# CLEVE HILL SOLAR PARK

ENVIRONMENTAL STATEMENT  
VOLUME 4 - TECHNICAL APPENDIX A7.5  
S42 CONSULTATION COMMENTS (LUC COMMENTS ON BEHALF OF KCC,  
SBC AND CCC)

**A7.5    TECHNICAL APPENDIX A7.5: S42 CONSULTATION COMMENTS**

(LUC comments on behalf of KCC, SBC & CCC)

**ZTV - Bare Earth**  
Figure 7.2

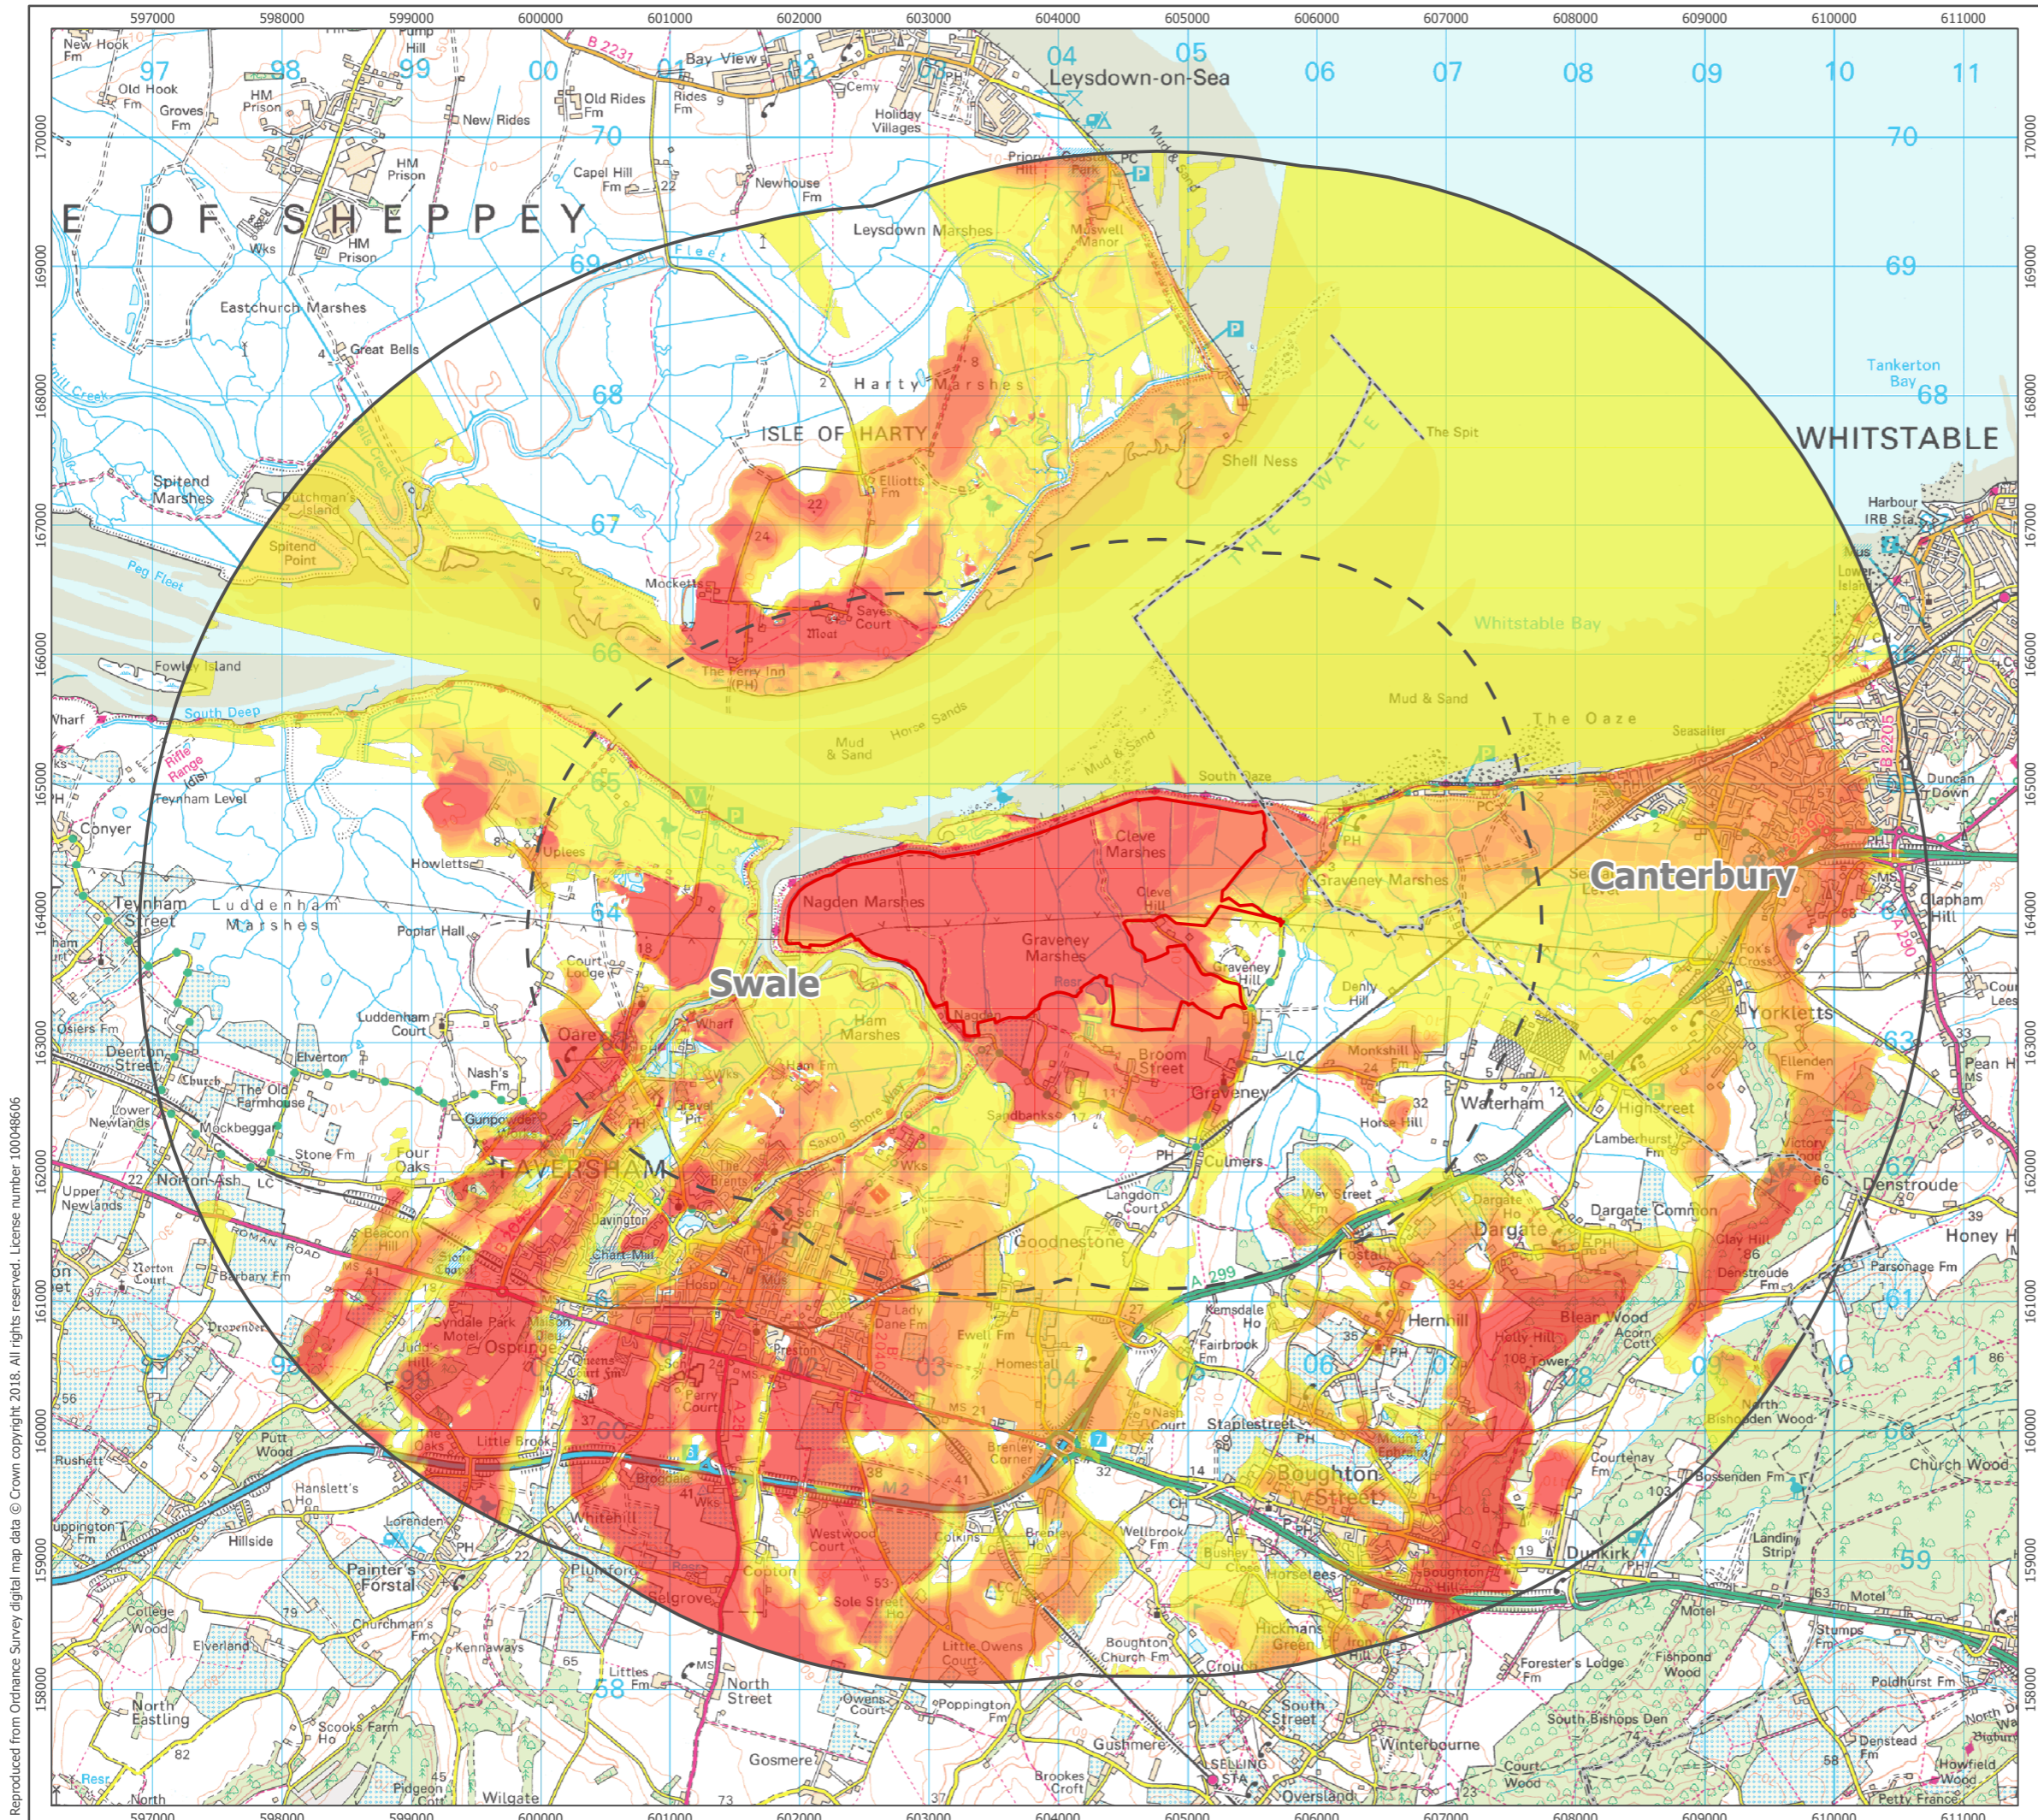
Kent County Council Appendix 1	1.13 Paragraphs 21 and 22 describe a larger study area for landscape effects than for visual effects. In our experience, effects on views are more likely to be significant at greater distances than effects on landscape character.	Landscape and visual study areas have been amended so they are the same and cover up to 5km. These are reported in Section 7.3 of Chapter 7 LVIA of the ES.
Kent County Council Appendix 1	1.14 The definitions of a Core Landscape Study Area 100m (CLS), Wider Study Area – 5km and Principal Landscape Study Area (PLS)/LVIA Study Area (2km) is confusing to the reader and greater clarity on the purpose of these areas and how they are used would be helpful.	Text has been amended to provide greater clarity on these study areas and they are used within the text. This is reported in Chapter 7 LVIA of the ES.
Kent County Council Appendix 1	1.15 The ZTV is only shown to 2.5km (Figures 7.2 and 7.3), whereas almost all the other figures show the 5km study area. Given that some of the assessment viewpoints are outside the 2.5km area, it would be helpful to see the wider ZTV. We recommend 5km is adopted as an appropriate distance for assessing visual effects as well as landscape.	ZTV has been re-run to cover 5km for Figures 7.2 and 7.3, these figures are shown in Volume II of the ES.
